Our ref: DOC26/273024-2

**EPA Advice on Modification Report – Modification 11 Karuah (East) Pit Consolidation
Project – MP09_0175-Mod-11**

I am writing in response to your request for the NSW Environment Protection Authority (EPA) to review the Modification Report for the proposed Karuah (East) Pit Consolidation Project (Application MP09_0175-Mod-11) located 5km northeast of Karuah township adjacent to the Pacific Highway.

Figure 4: Extract of Approved Karuah East Quarry Site Plan (MOD 10)

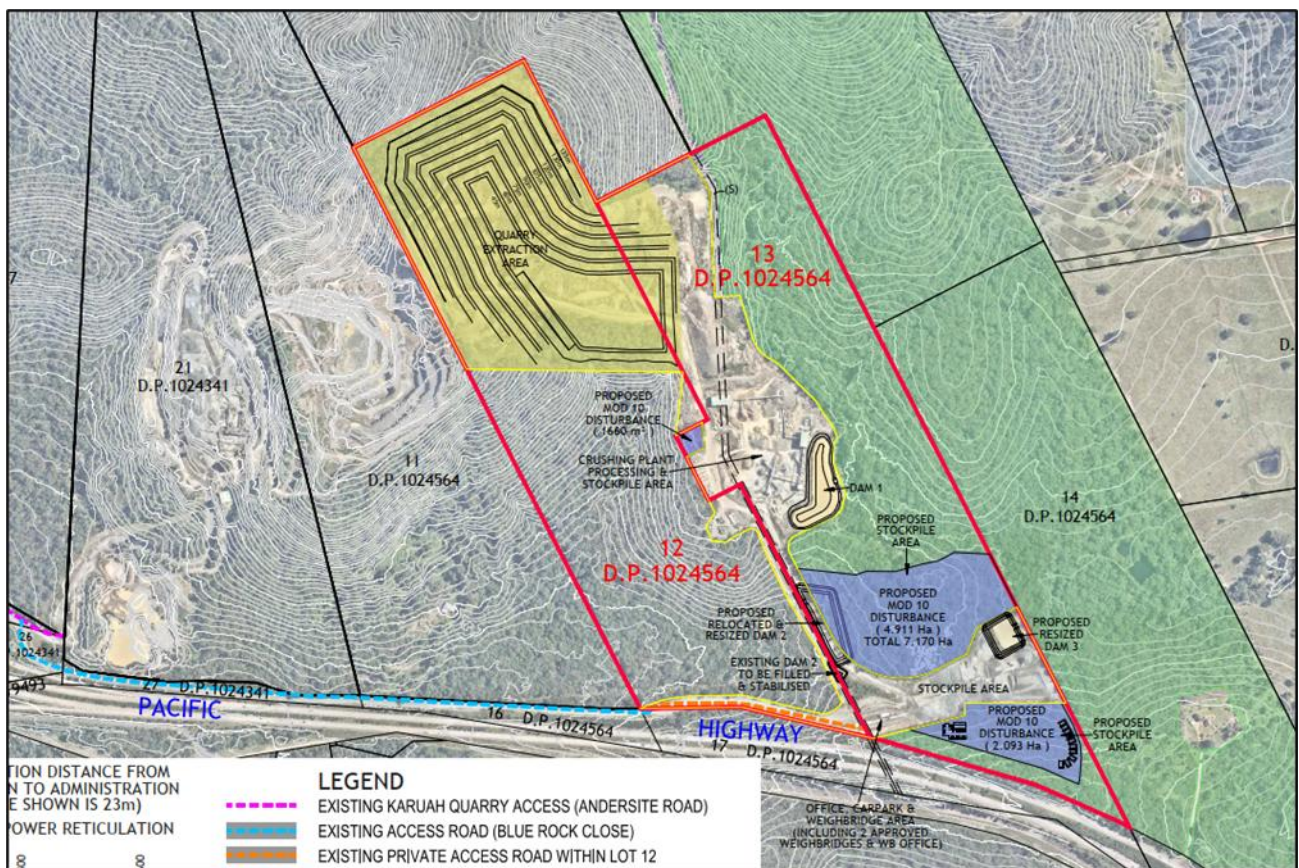
The SWA identifies several site modifications, including the relocation and resizing of Dam 2, resizing of Dam 3, and an expansion of the stockpile area. These changes were approved in Modification 10. Any cumulative water quality impacts from the approved Modification 10 should be clearly assessed in conjunction with the current proposal.

Appendix C – Catchment Plan

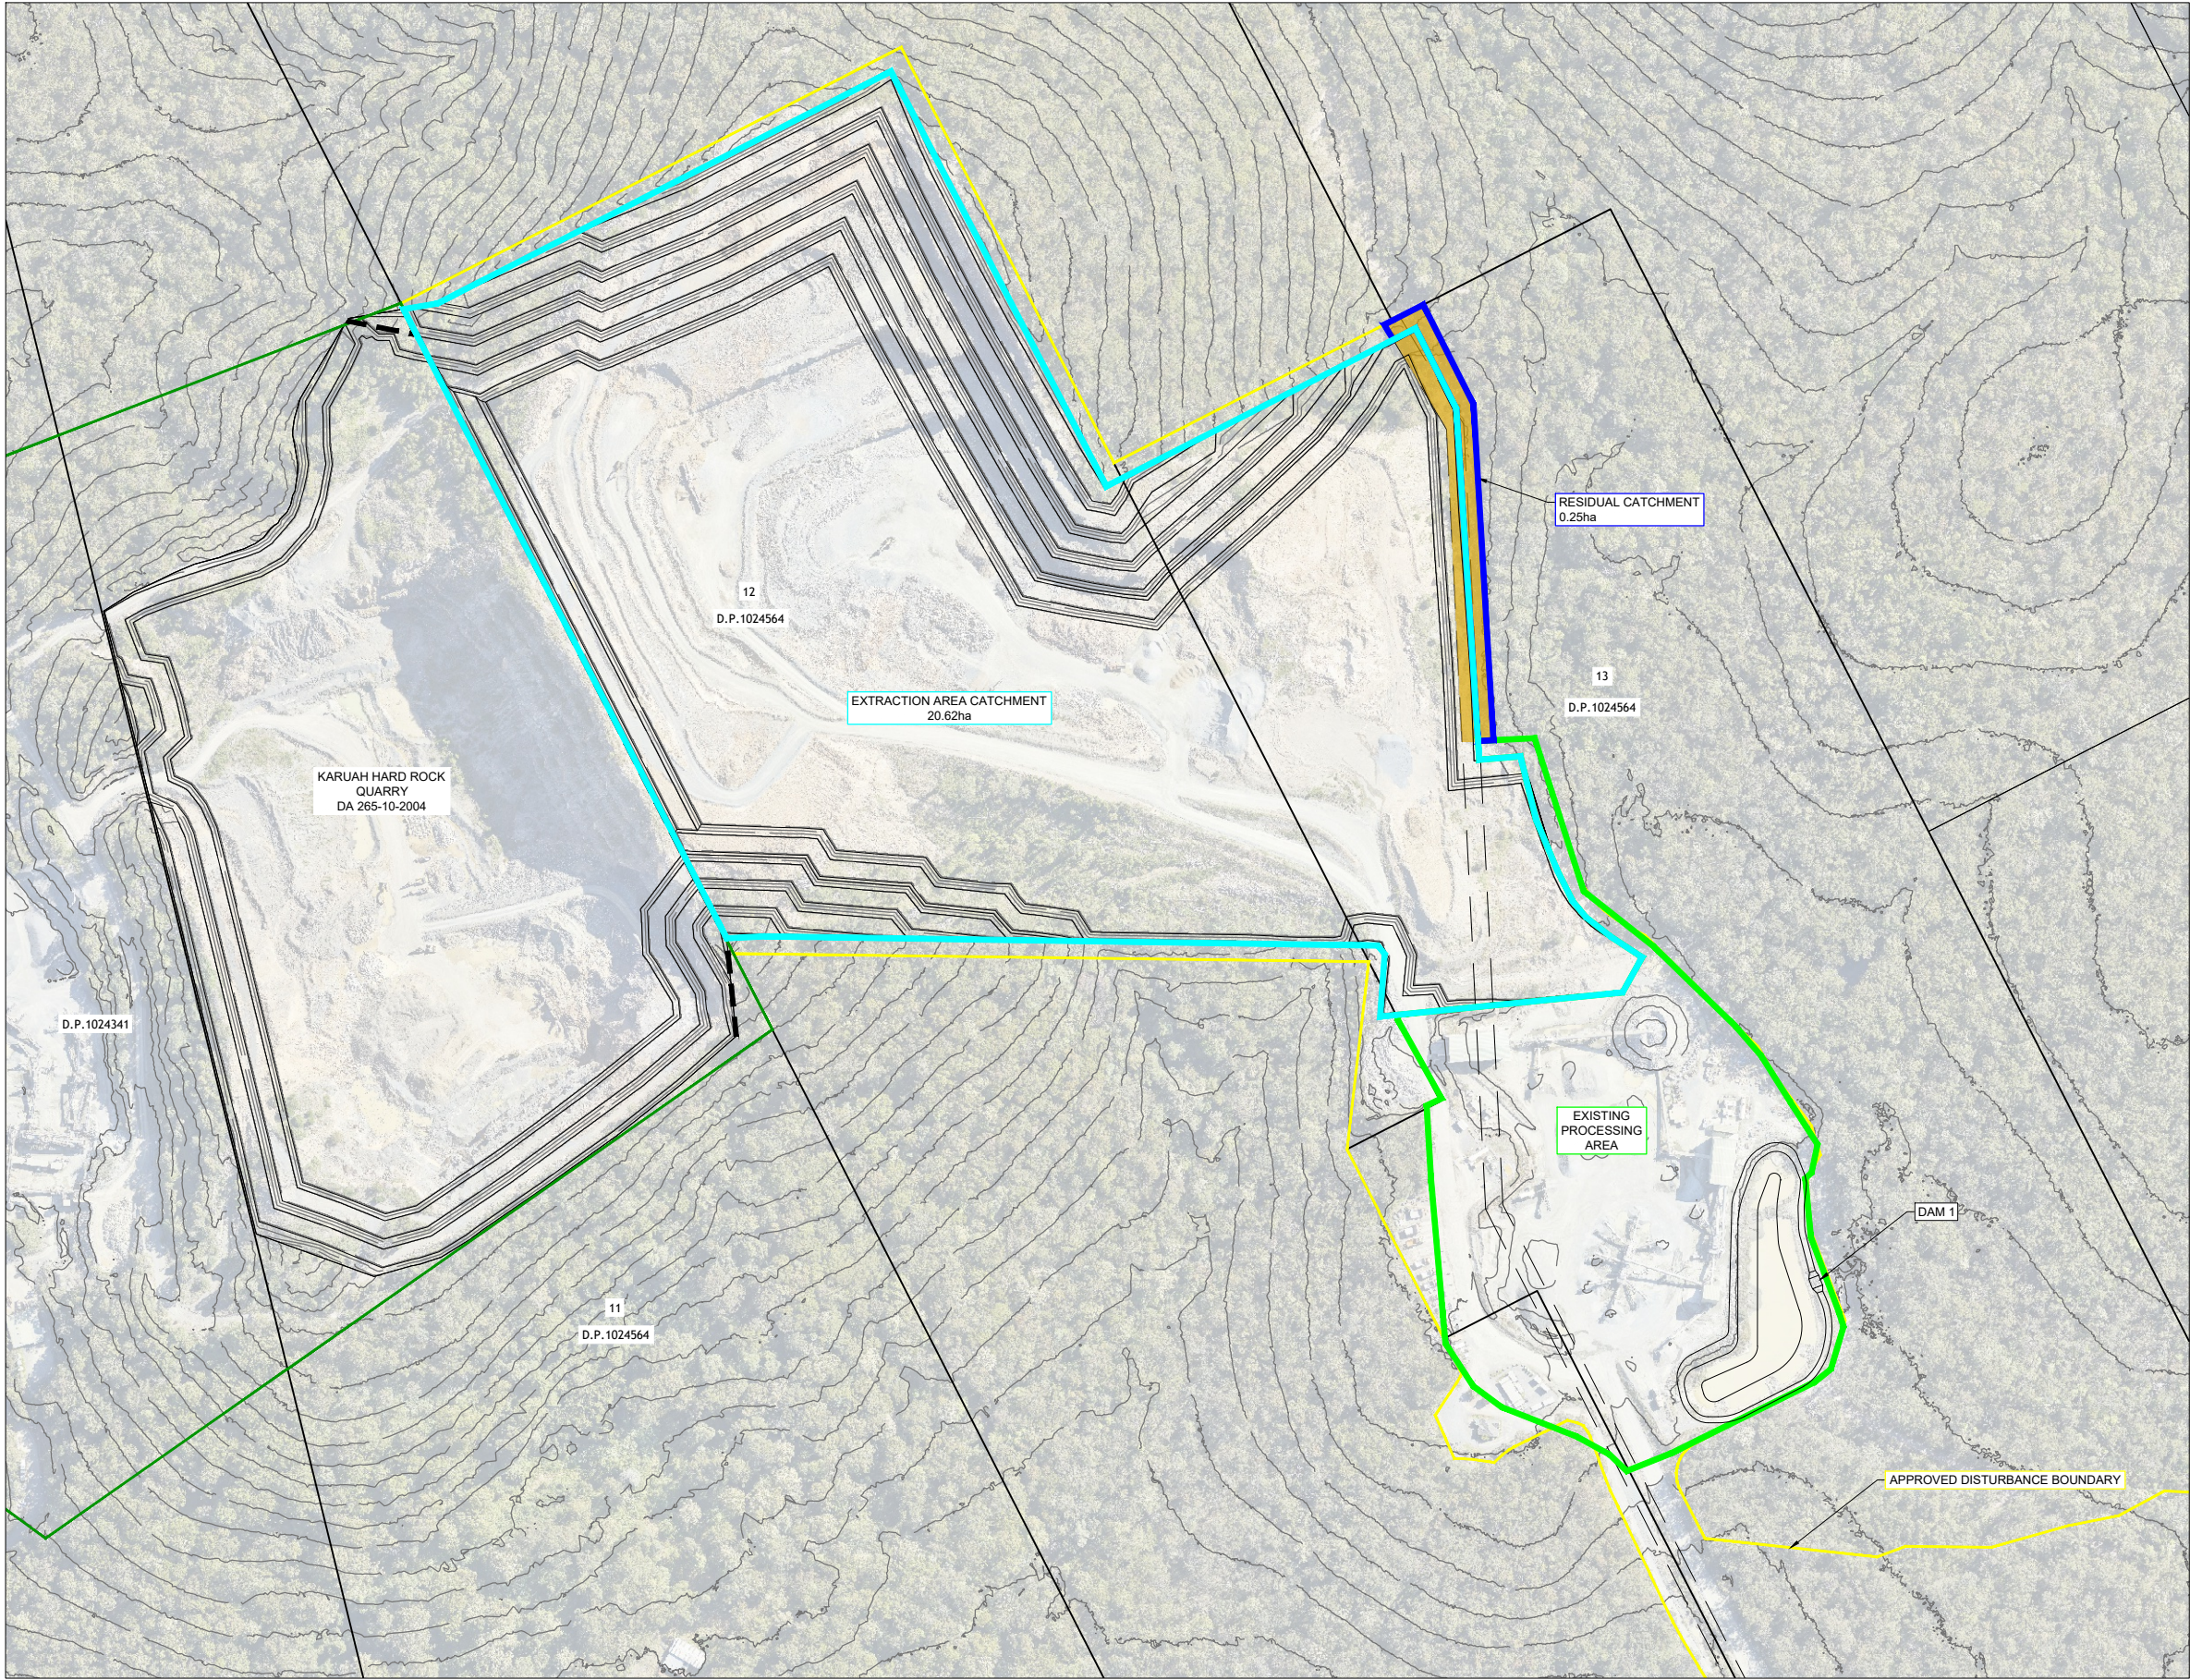
The EPA has reviewed the Surface Water Assessment (SWA) and notes that, following the highwall removal between KEQ and KHRQ, surface water will naturally flow towards KEQ. The extraction pit catchment is expected to increase from 14.4 hectares to 20.62 hectares.

Mitigation measures are proposed to include the construction of a bund wall along the Lot 11/12 boundary to separate flows, and an increase in the capacity of the in-pit sump. However, the EPA notes that the increase in the catchment area may result in a corresponding increase in discharges from the premises.

- Update the area (hectares) of exposed land used in the modelling of surface water quality impacts and ensure it is representative of the proposed future operations on the consolidated site. For example, the intended clearing of vegetation for the “Approved Stockpile Area”.

- Detail the frequency, duration and volumes of water proposed to be discharged from the stormwater detention basins under a range of operating scenarios, including worse case conditions.
